**STATE SIGNIFICANT DEVELOPMENT APPLICATION 61400212  
APPLICANT: THIRD.1 GROUP**

**North Sydney Council Response to RTS  
25 Hume St Crows Nest Site B OSD**

**SITE:** 25 Hume Street CROWS NEST 2065  
SSD-61400212 - Crows Nest OSD Site B Proposed over station mixed use and residential development comprising of: 122 Residential units and 78 above ground car spaces

To provide urban design comments on the amended Development Application (SSD-61400212) – Crows Nest Metro OSD Site B (dated 19 August 2025). This advice should be read in conjunction with advice prepared in November 2024.

Sheet title  
CARPARK LEVEL 05

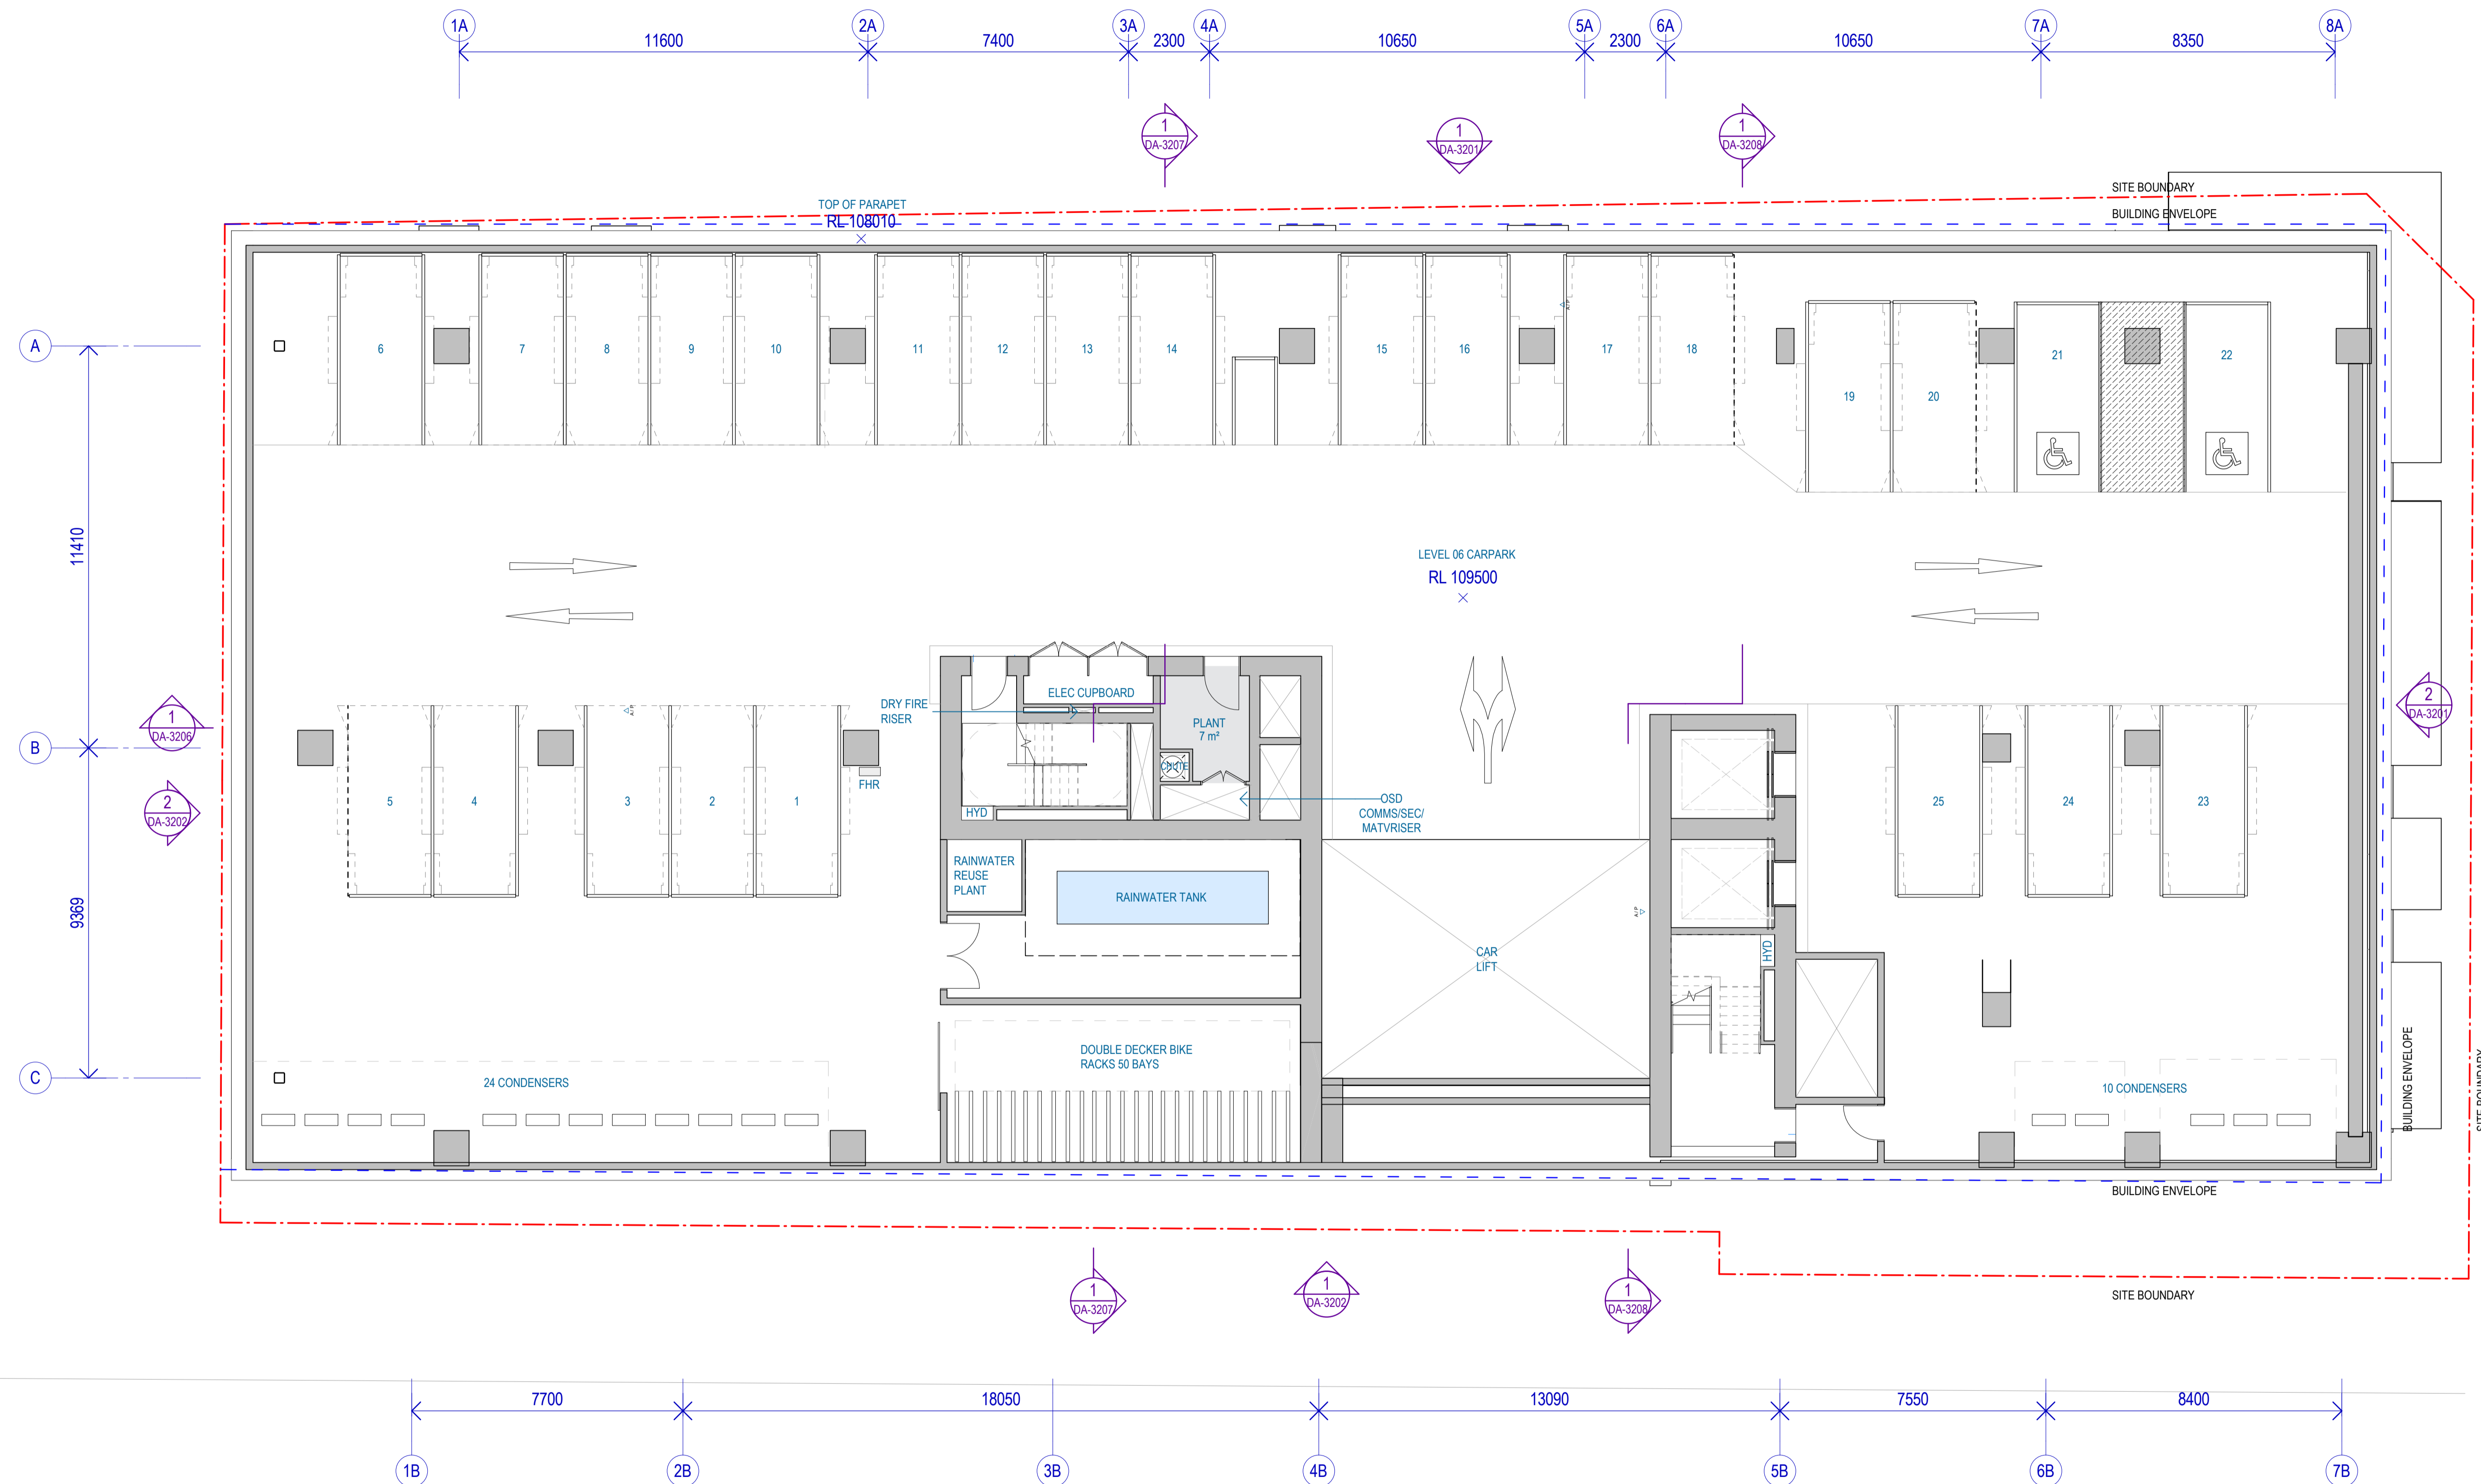
- 3.1 The amended design adds a third car parking level (Levels 5–7), maintaining an almost no setback to the shared southern boundary. Previous Urban Design advice raised concerns that these open-façade (featuring perforated metal panels) car park levels directly interface with the adjacent site, which is planned for redevelopment with a 3-storey street wall and residential uses above.

3.2 The nil-setback interface would directly overlook future residential units, negatively impacting privacy, noise, air quality, and visual amenity. The additional level in the amended design worsens these effects, further reducing the residential amenity of the adjacent site.

3.3 A three-storey car park that reaches up to level 7 is an entirely inappropriate land use above a metro station where employment, population serving activities, additional housing or community facilities would be more appropriate.

5.1 The amended design replaces residential units with car park spaces on Level 7, increasing the total spaces from 55 to 78.
